Ann Machado - Permit #2014-00520, 8 Crescent Ave., GDI

I have done my initial zoning review and at this point I cannot sign off on the permit. I need some more information.

Drawing file: 1. Original Plans / Deck Plan 2.pdf

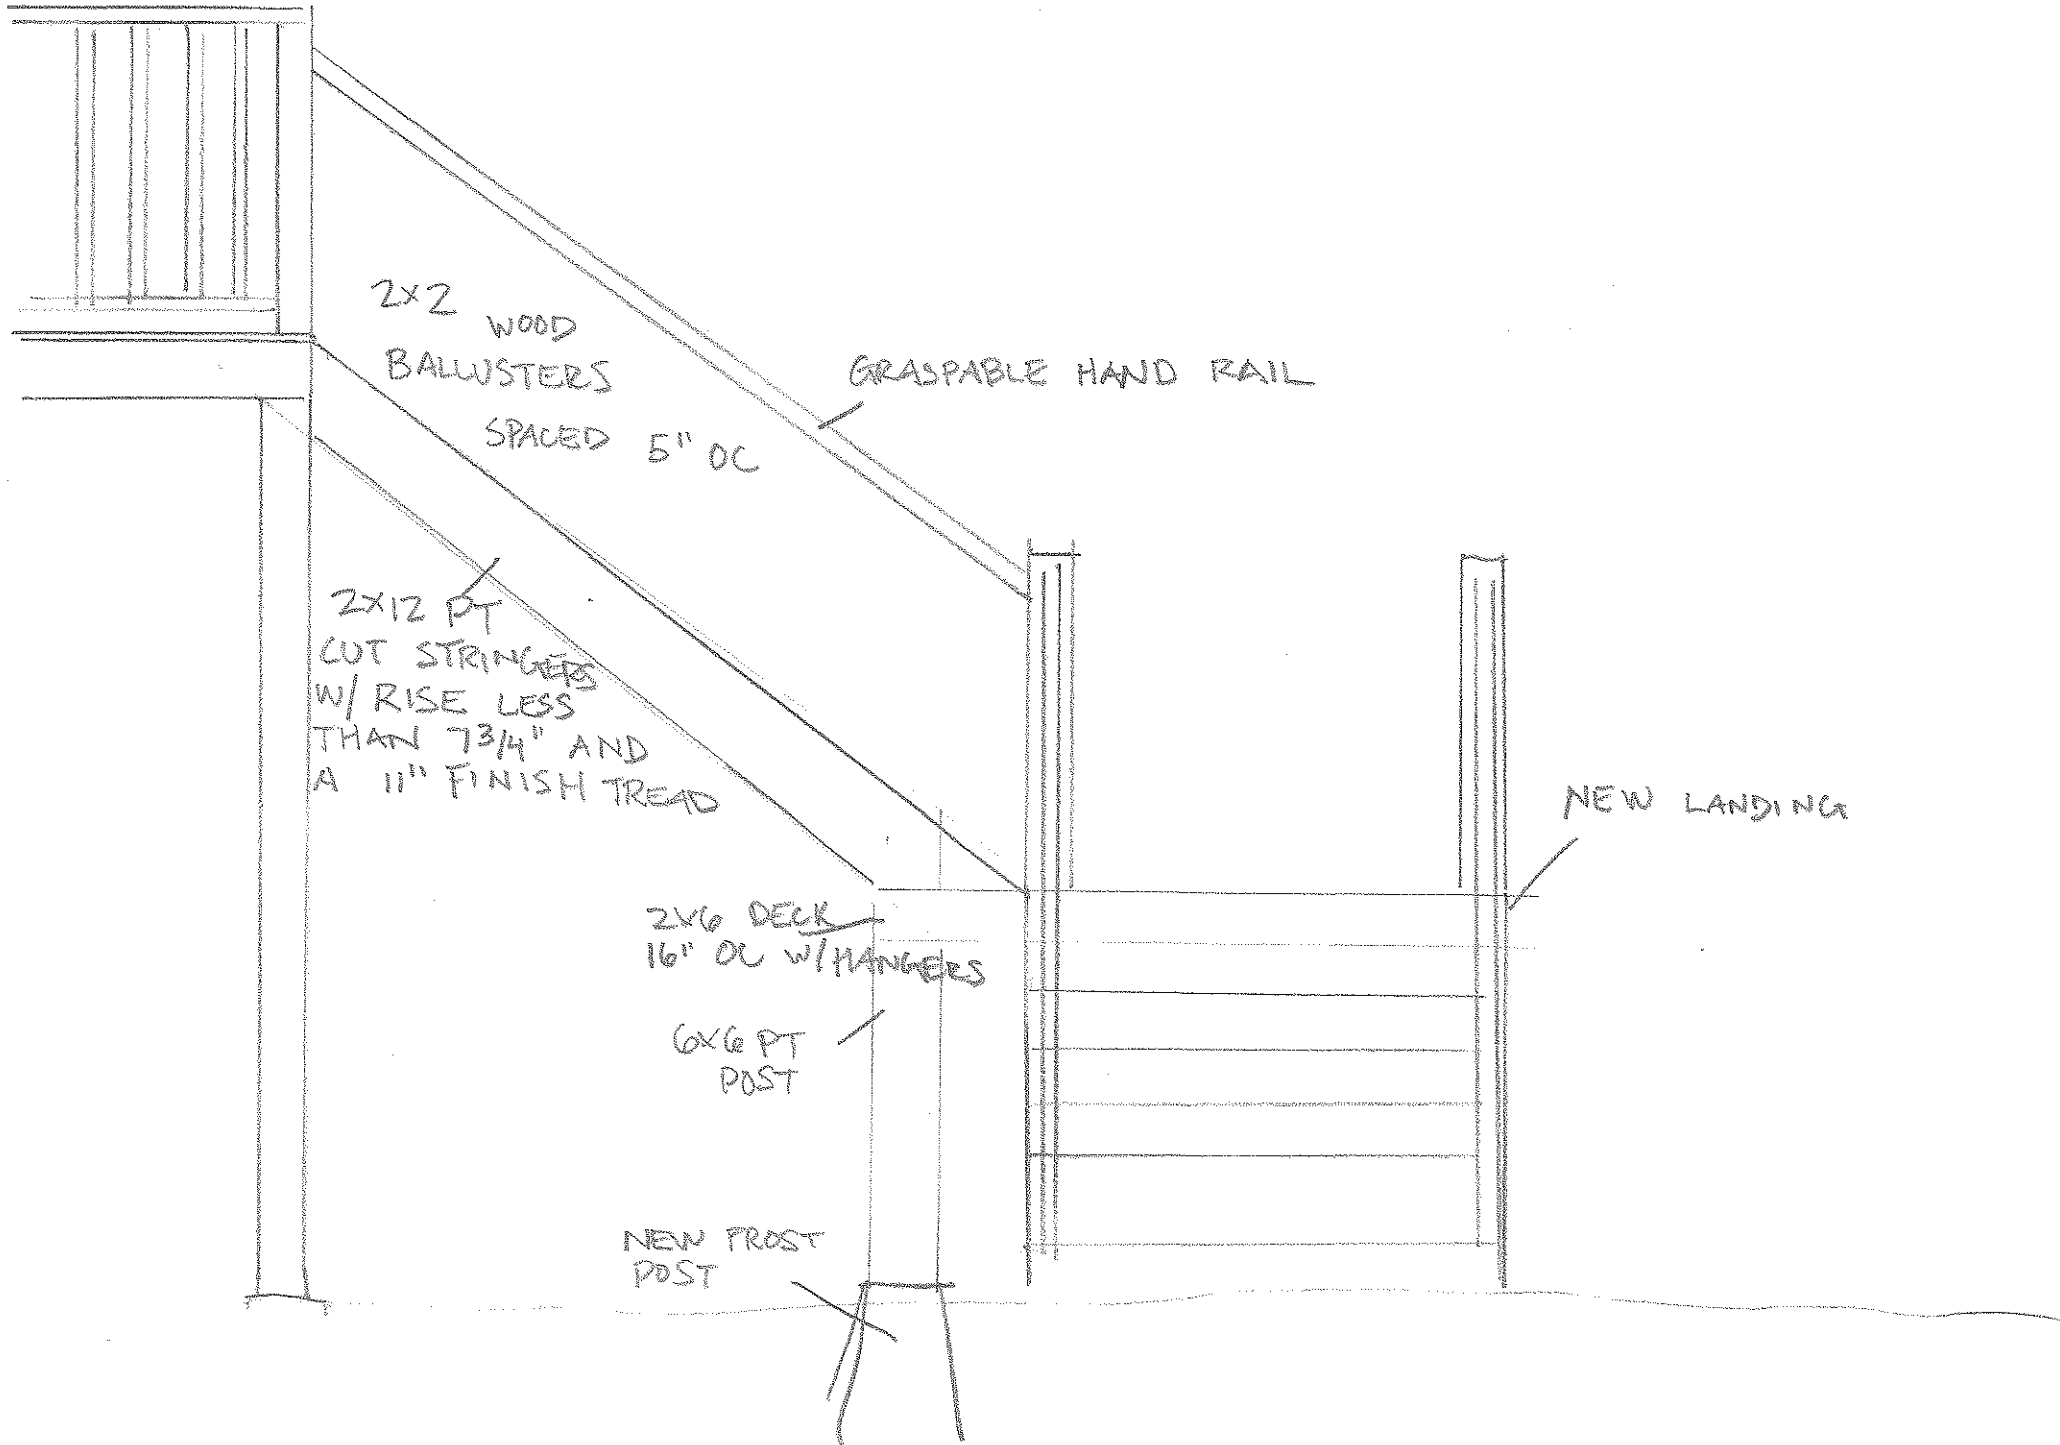
2 Is the 42' x 10' deck a new deck or is it replacing an existing one?

3. The plot plan does not show the stairs and landing coming off the deck that the deck Plan 2 plan shows.

BOUNDARY PLAN
 8 CRESCENT AVENUE GREAT DIAMOND ISLAND, PORTLAND MAINE 04109
 Owner:
DIAMOND ISLAND ASSOCIATION
 8 CRESCENT AVENUE GREAT DIAMOND ISLAND, PORTLAND MAINE 04109
 Prepared For:
TRAVIS BERUBE BUILDERS
 67 BOOTHBY AVENUE, SOUTH PORTLAND MAINE 04106

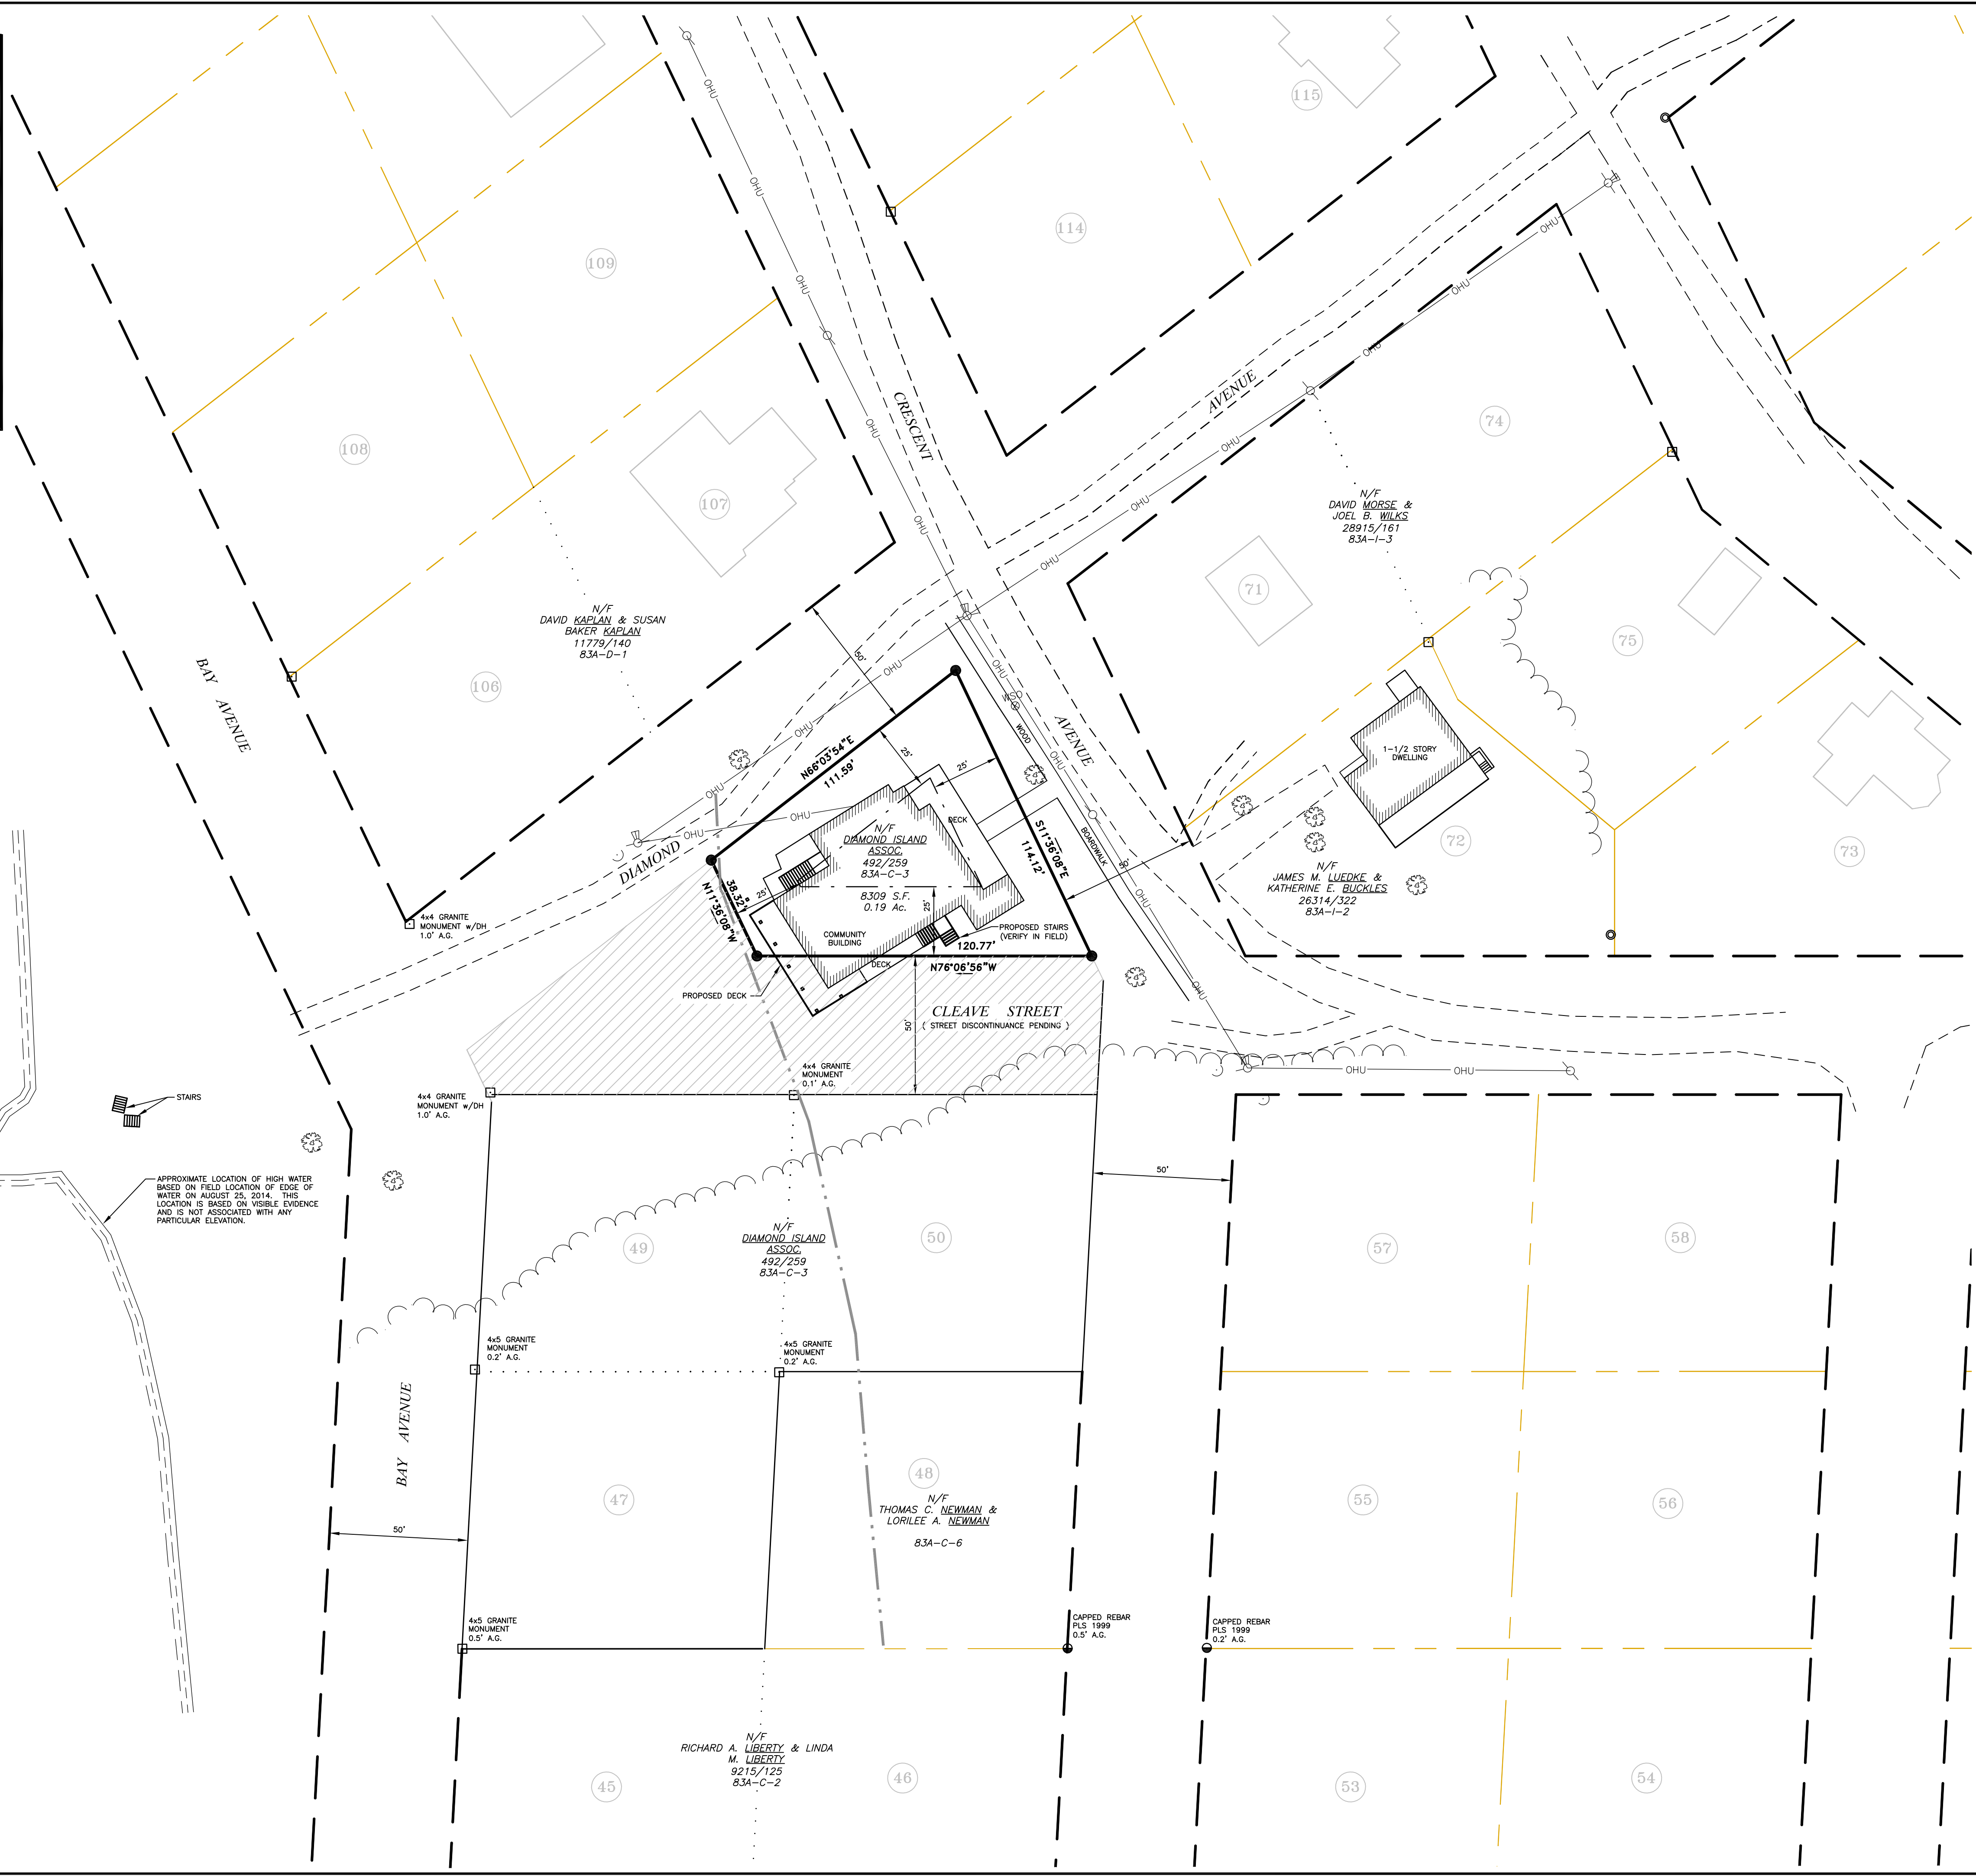
1. I'm not sure where you are getting the dimensions for the plot plan. The community hall is located on lot 083A-I-001. This lot is only 8712 sf. I understand that Diamond Island Assoc. also owns lots 083A-C-003, 004 & 005, but this is located across Cleeve Street which appears to be an island right of way. Also part of the plot plan seems to encroach in the Diamond Ave. right of way. I need to see the deed or some kind of evidence that the plot plan and setbacks are correct.

4. The footprint of the building on the plot plan does not match the footprint of the building on the assessor's sketch.
